Response to Submissions and Preferred Project Report

Nepean Hospital - Derby Street, Kingswood Stage 3A - Integrated Mental Health Unit Development

Submitted to
Department of Planning
On Behalf of NSW Health Infrastructure

November 2010 ■ 10486

1 PROPOSED SHADOW DIAGRAM - JUNE 9AM
1 : 1000

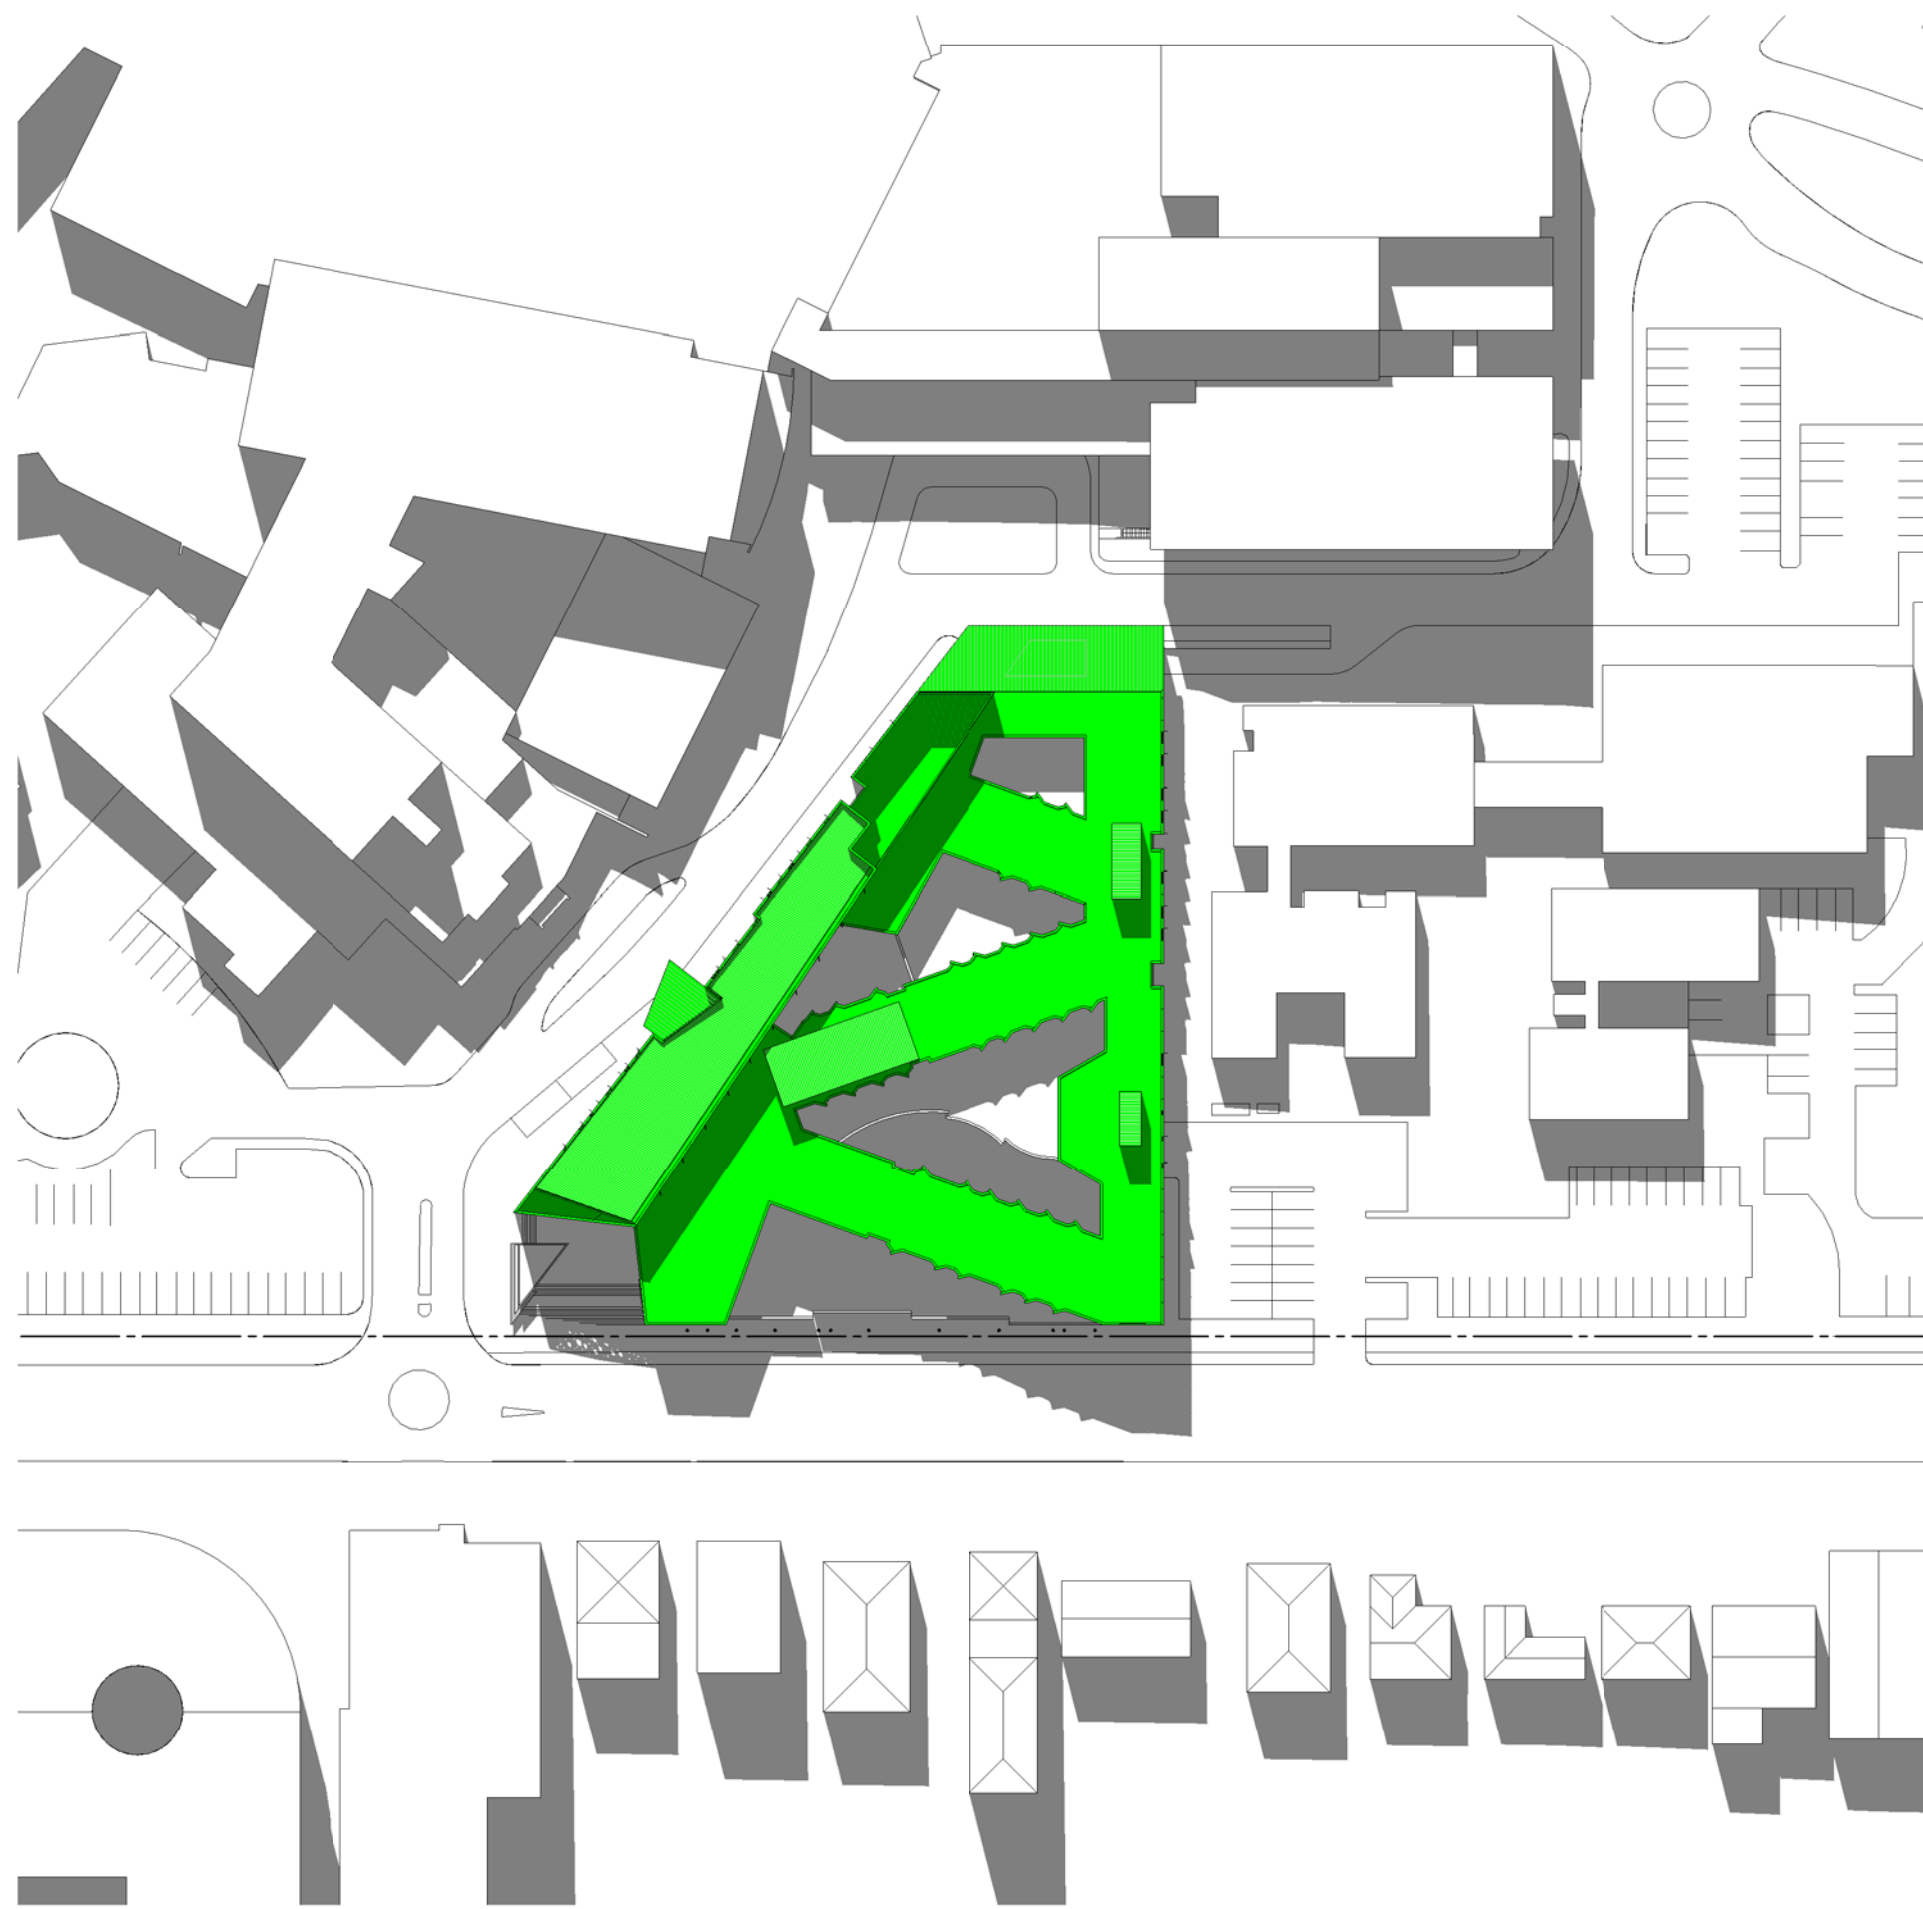
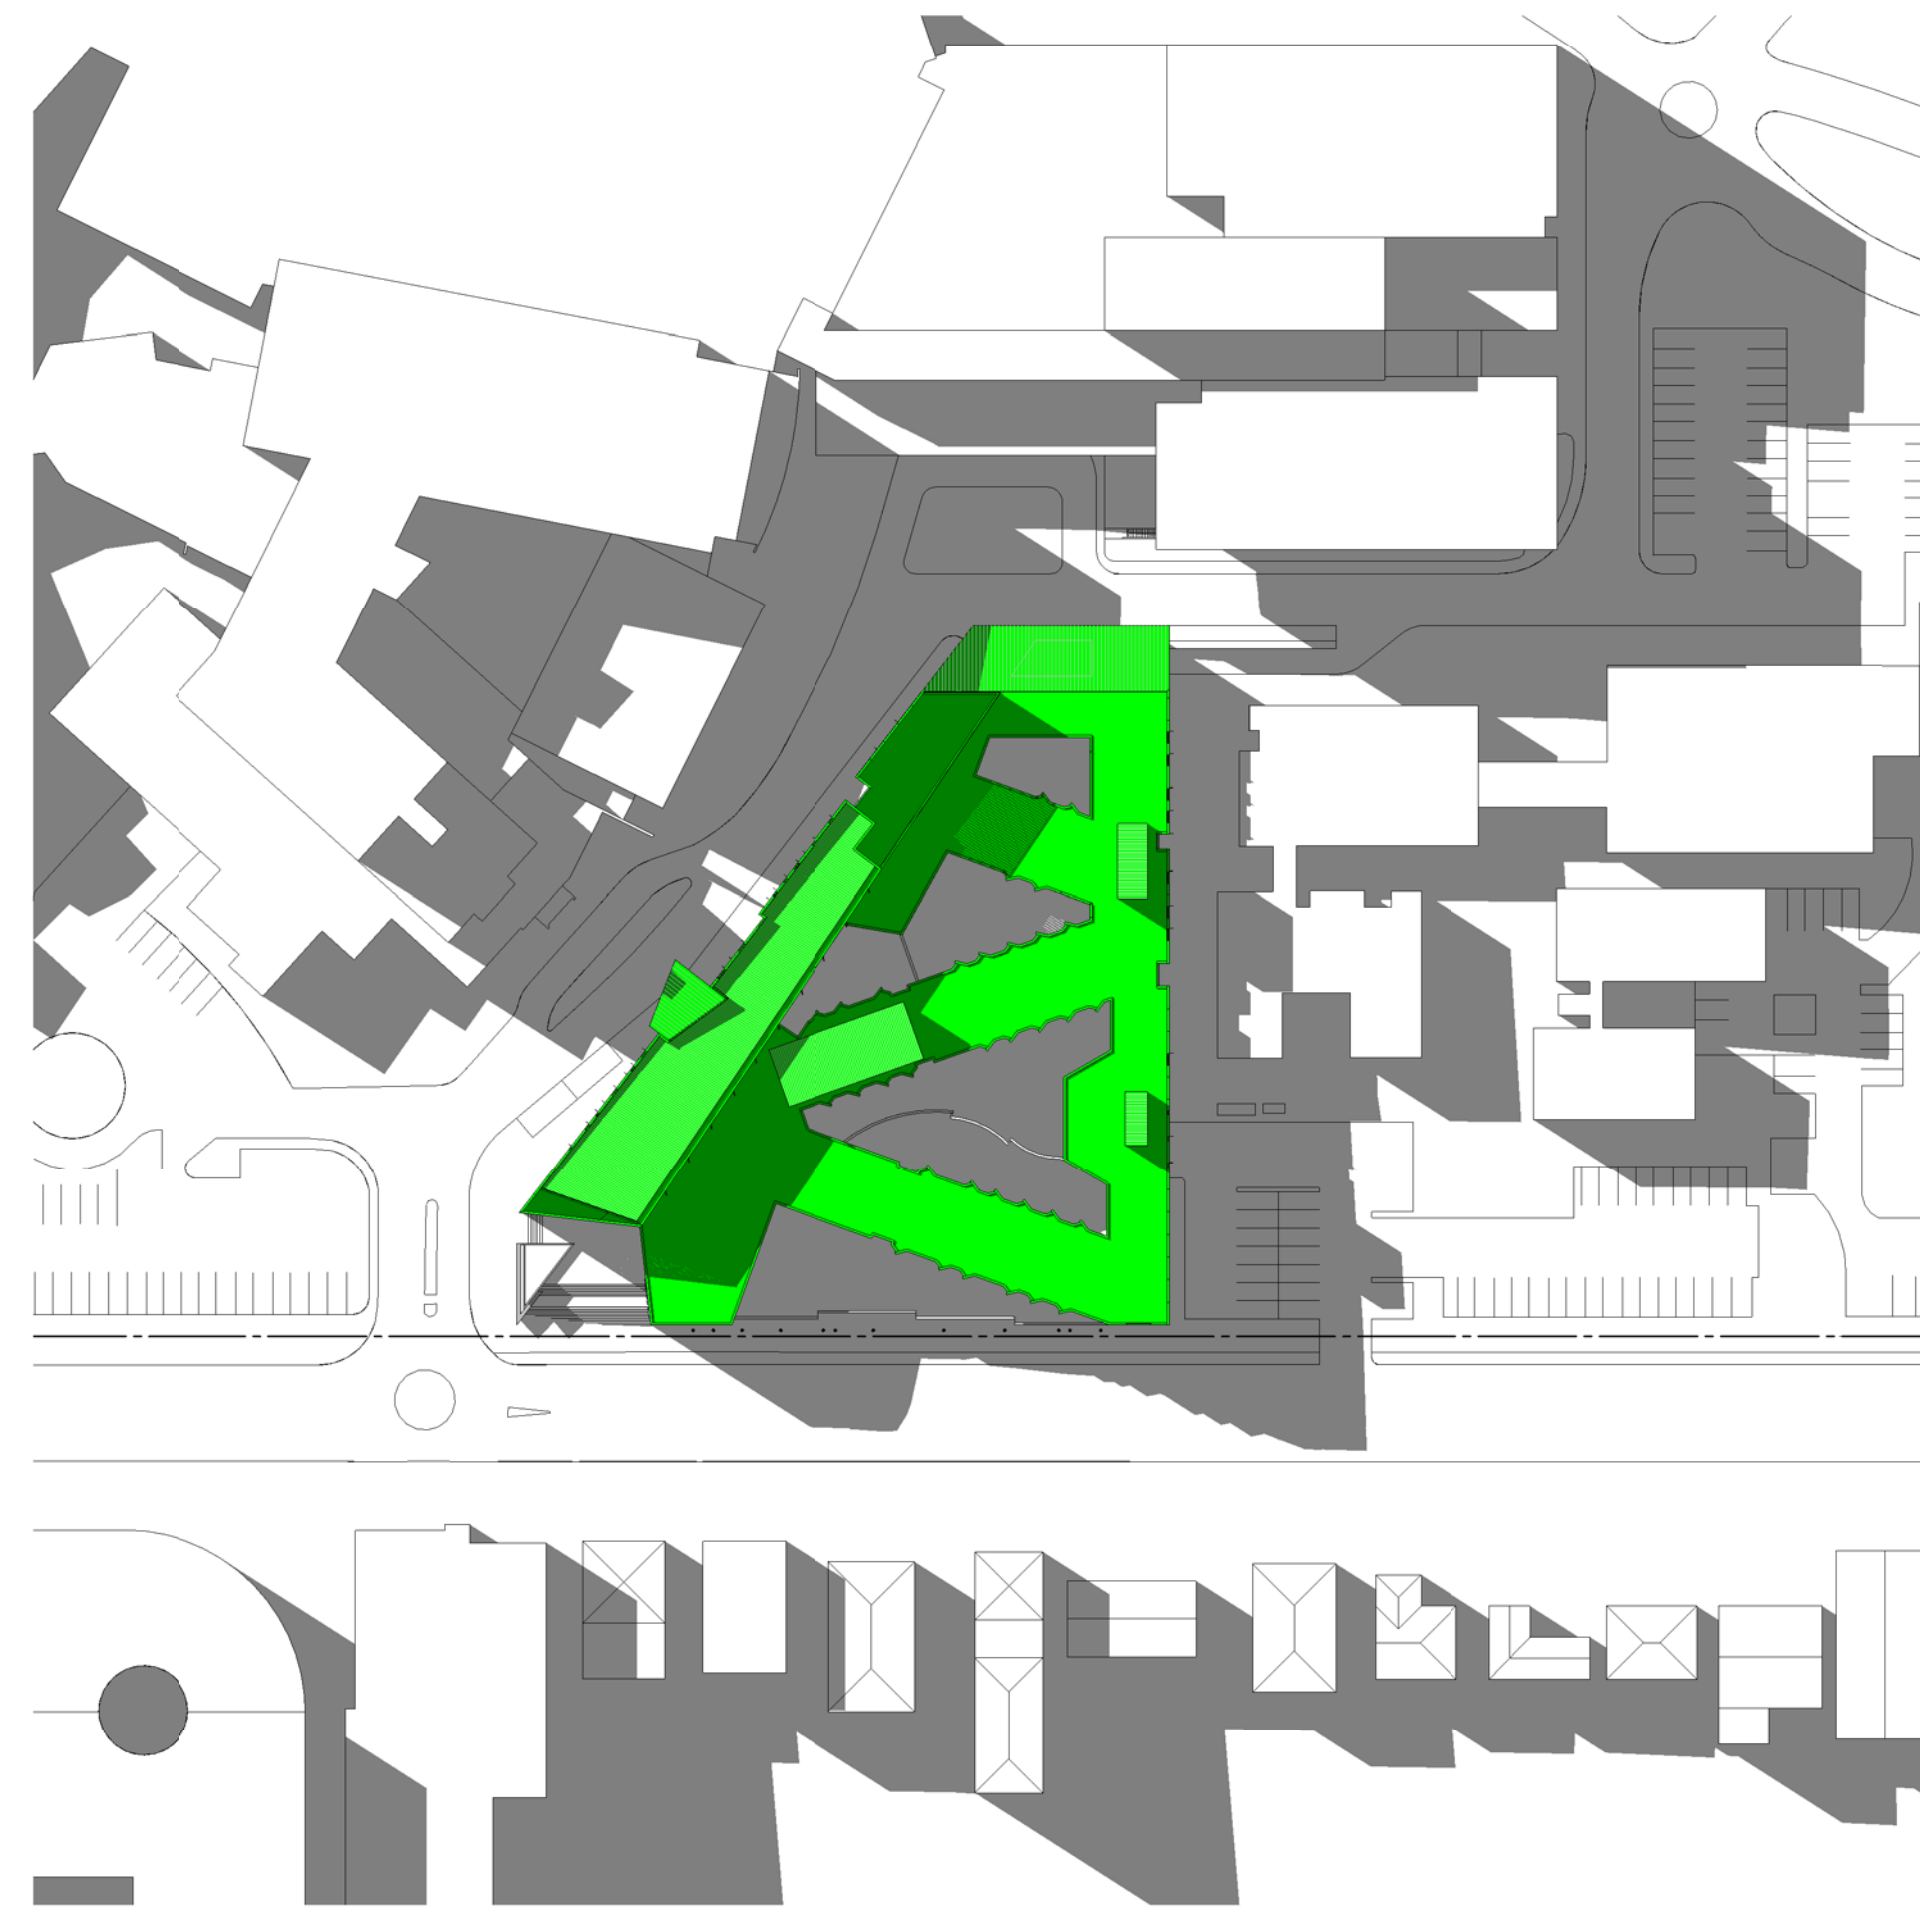
The key consideration of the additional height would be overshadowing to the properties to the south of Derby Street. The exhibited scheme's March, June, September and December shadow analysis showed that there was no affect upon neighbouring properties and that all solar access requirements to living rooms between 9am and 3pm could be achieved, where those properties on Derby Street are residential in use.

The revised scheme's shadow analysis demonstrates that there is similarly no effect upon residential properties in March, September and December. Indeed the shadows are little changed despite the height increase. In June, the 9am shadow now hits two properties, one of which is a medical consulting room. By noon, these shadows have receded and affect only the road carriageway of Derby Street. Accordingly, the revised scheme does not adversely impact upon neighbouring residences as a further minimum of 3 hours of solar access is achievable as presently enjoyed by the two affected premises.
